Jeanie Bourke - Re: 7 Forest Ave, BP# 2014-00234 plan review comments

From: Jeanie Bourke
To: andreaahelm1325@gmail.com
Date: 3/6/2014 3:23 PM
Subject: Re: 7 Forest Ave, BP# 2014-00234 plan review comments

I have completed my review and have a few questions:

**2ND FLOOR**

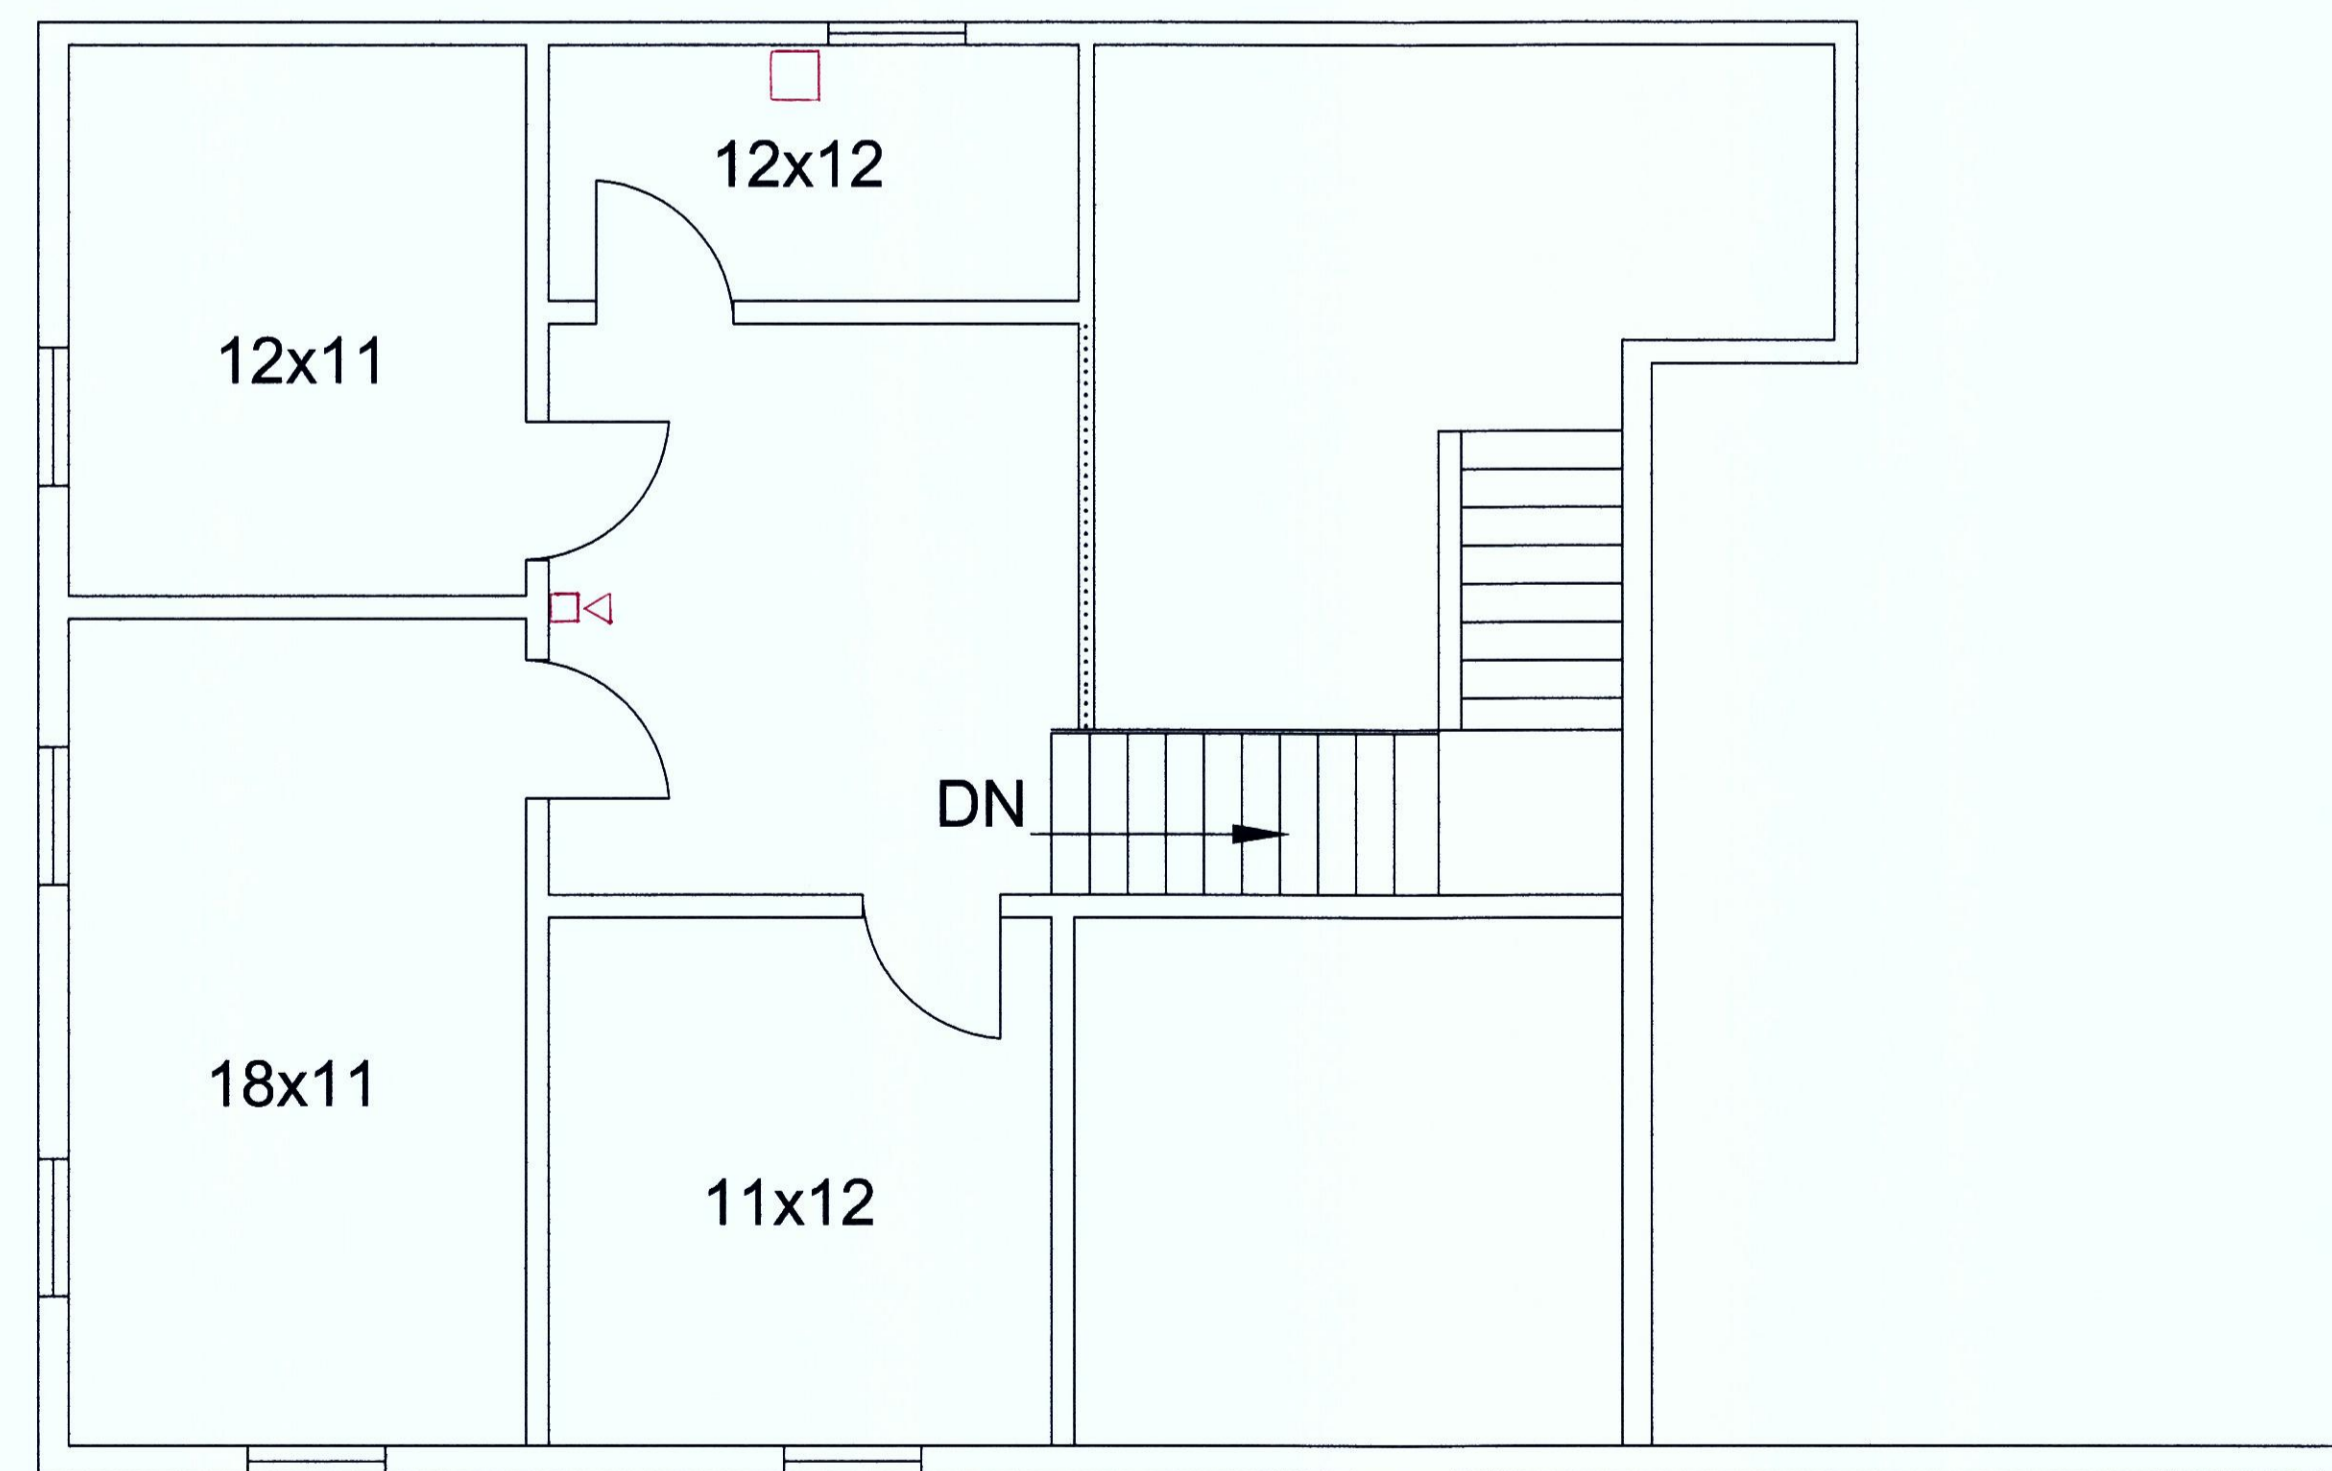
1. Is Suite B the only area of the gallery, 300 SF? Are the other Suites separate businesses? Does each suite have a door or are they all open? **Yes**

2. Do the stairs go directly to the outside on the first floor or do they enter into a common area? Is there a door at the stairs or is this open? **There is a door and stairs go to an entry/vestibule on the first floor and exit. There is also another stair from the 2nd floor not shown on these plans.**

3. I assume there are bathroom facilities, can you let me know where this/these are located? **There are bathrooms on the 2nd floor.**
